Our ref: L01592148
20 June 2025

**Arrangements for Handling Heritage Applications Direction 2021
& T&CP (Development Management Procedure) (England) Order 2015
& Planning (Listed Buildings & Conservation Areas) Regulations 1990**

**GEORGE HOTEL, ST GEORGE'S SQUARE, HUDDERSFIELD, HD1 1JA
Application Nos 2025/65/91148/W & 2025/48/91147/W**

JOHN WILLIAM STREET WALL

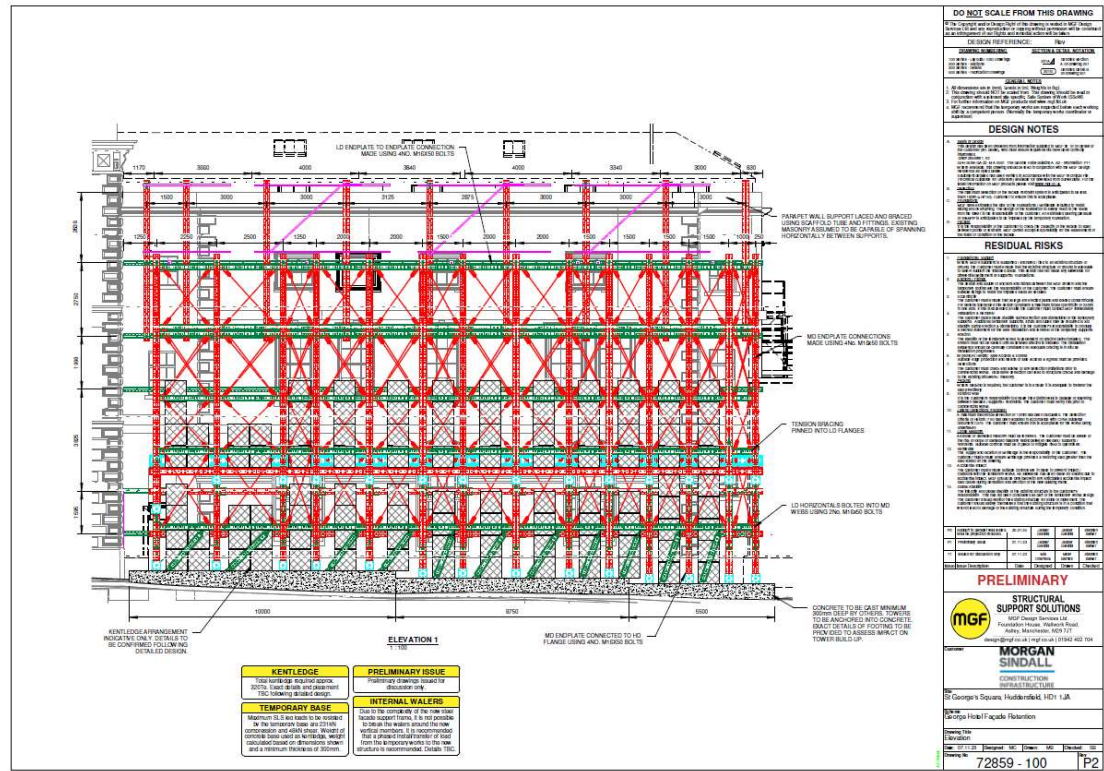
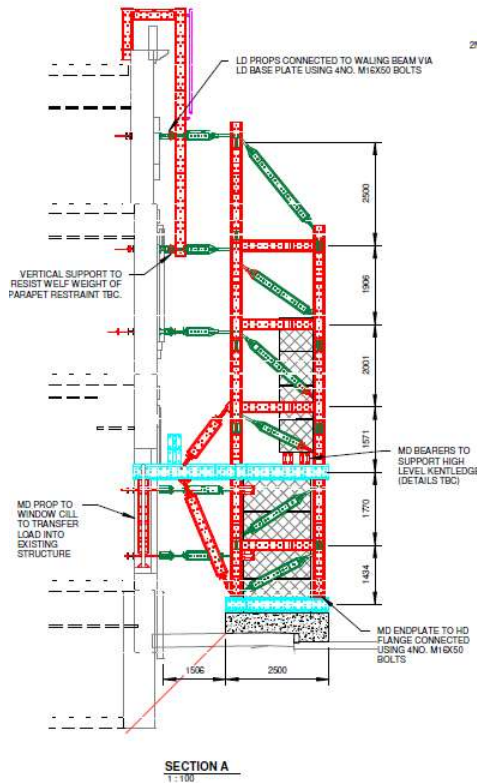
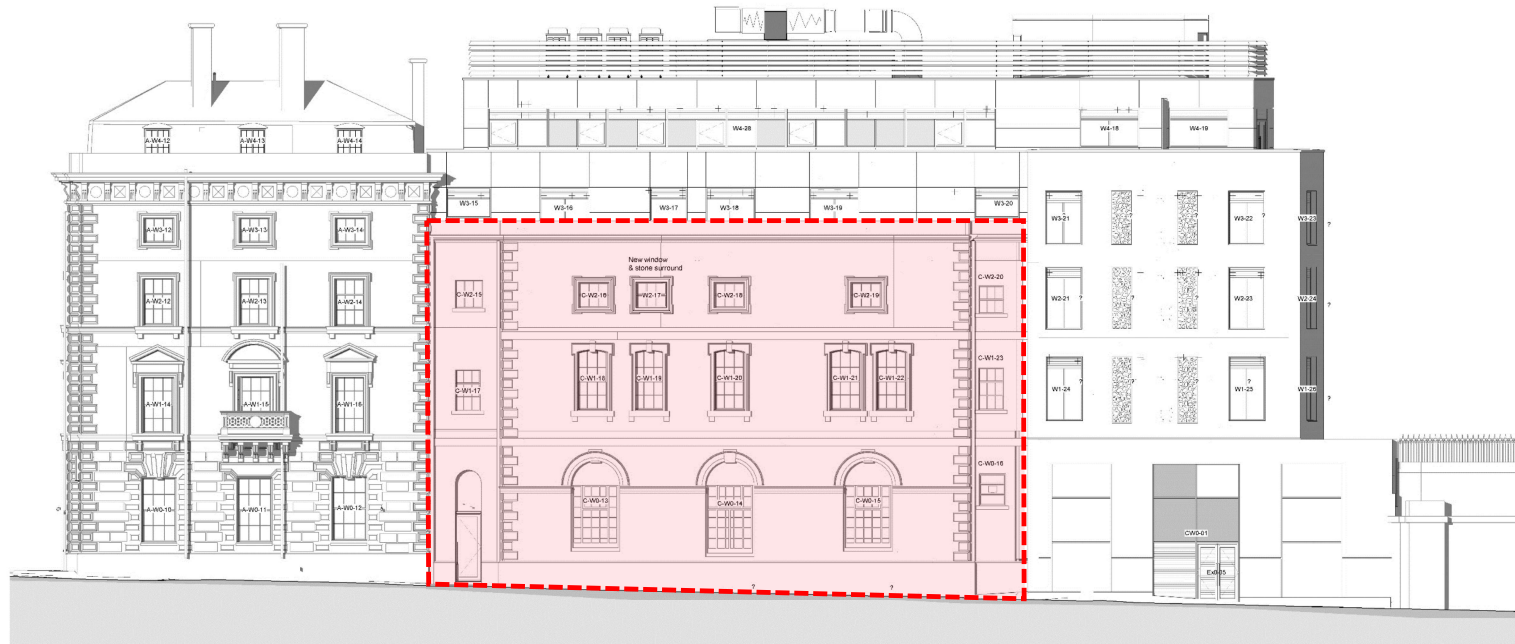
The proposal is to demolish, or take down, the John William Street elevation, record the individual stones and then rebuild the elevation in its original location whilst altering some of the fenestration.

This would cause a moderate level of less than substantial harm to the significance of the listed building through diminished evidential values and therefore this harm should look to be clearly and convincingly justified and outweighed by any public benefits which are considered to arise from the proposal. The need for clear and convincing

We would require the structural work carried out by the structural consultants to be presented to understand the financial and structural need to demolish and then rebuild the John William Street elevation. These documents should robustly demonstrate this need to ensure the clear and convincing justification is provided.

Sketch Drawings / Mark-ups.

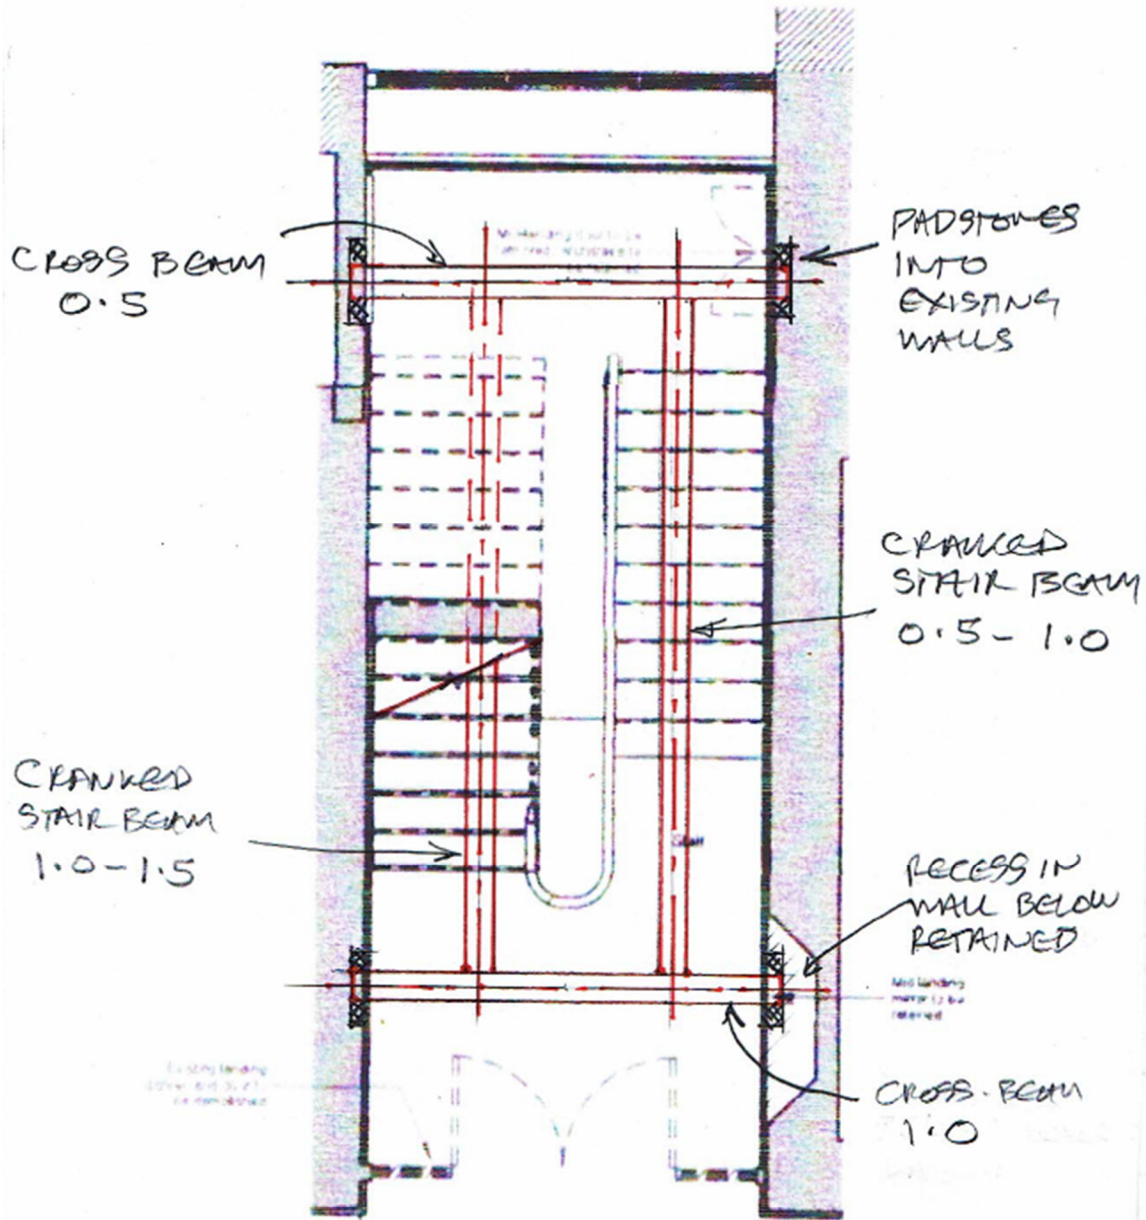
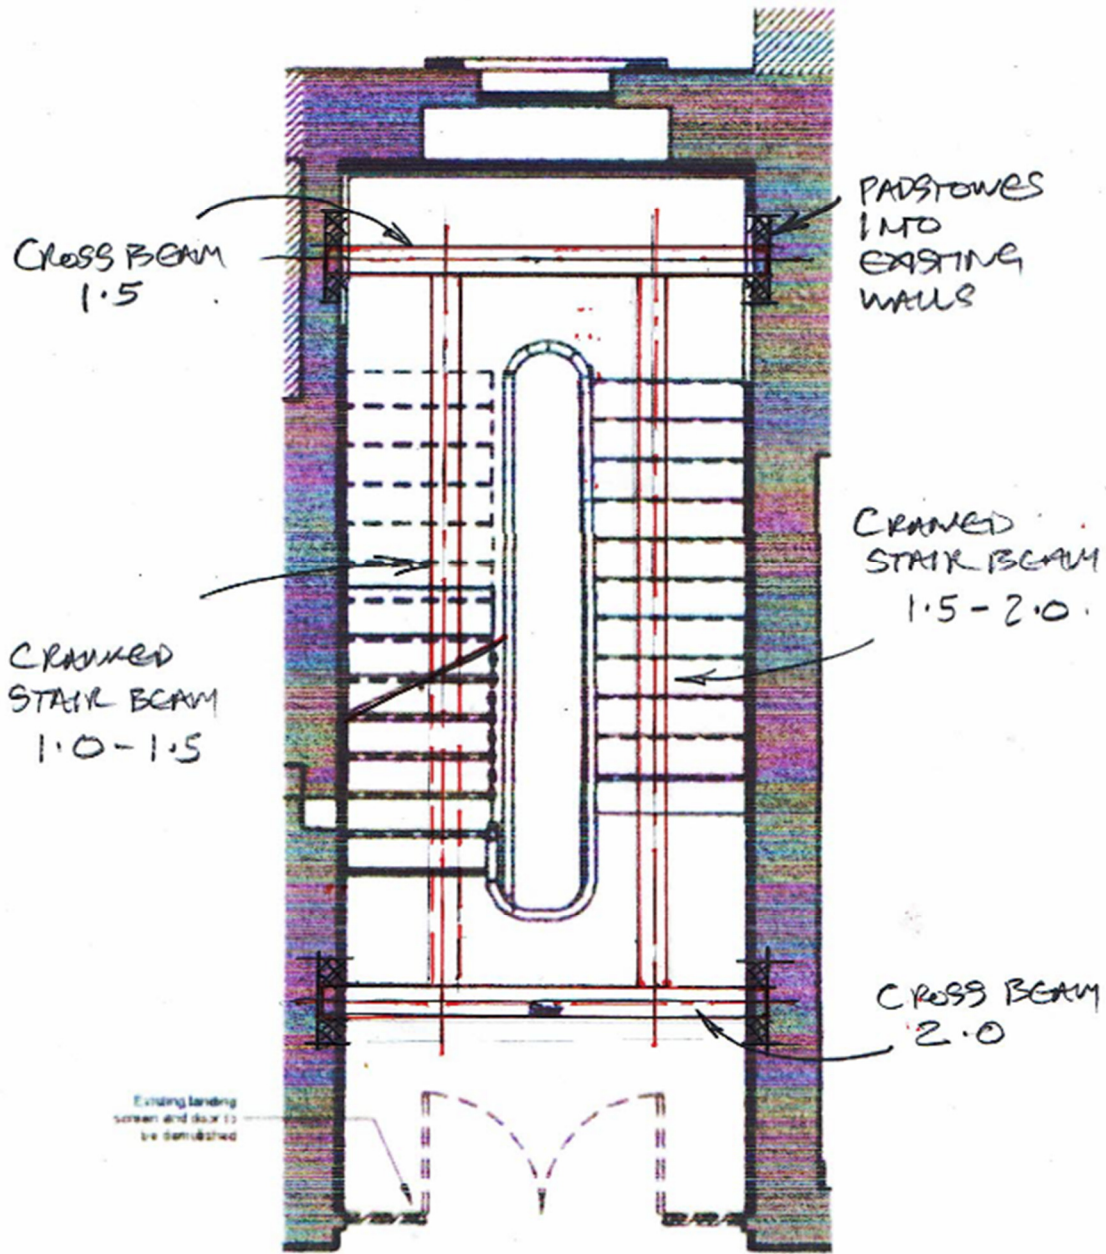
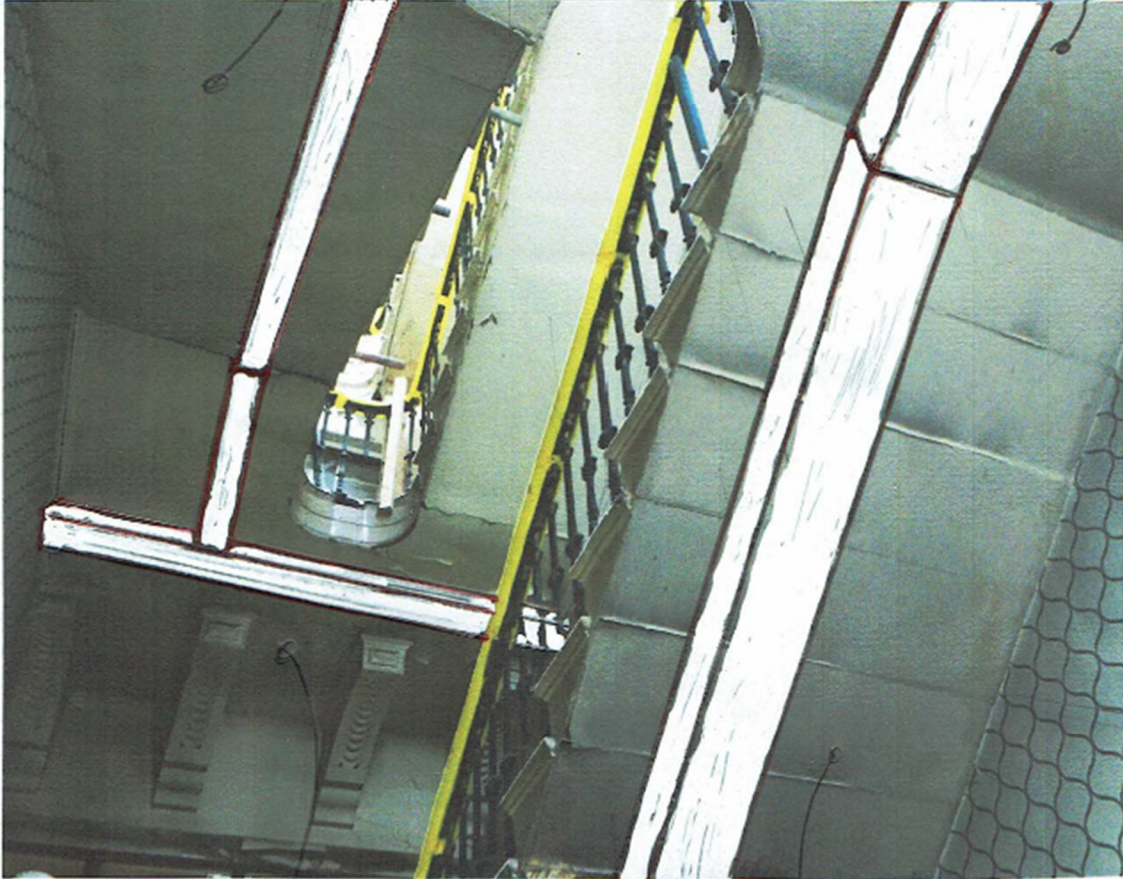
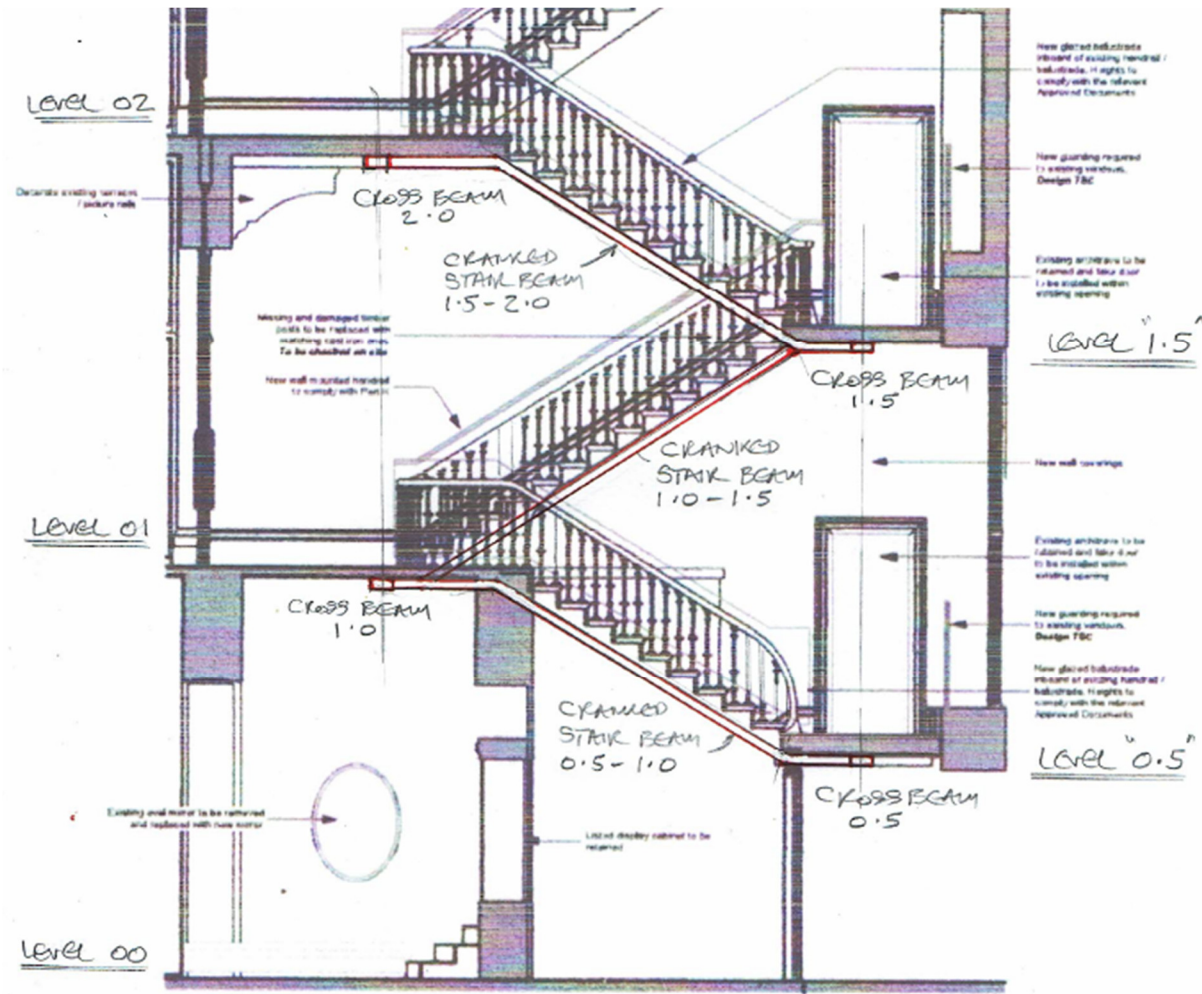
We have some concerns about the potential cumulative harm which could be caused by some of the interior elements in Block A such as the visual impact of service rafts, lighting design in significant spaces, and the design of the balustrade to improve stair safety.

We acknowledge that it is a necessity to improve stair safety however we would ask the applicant to explore design options to lessen its potential visual impact.
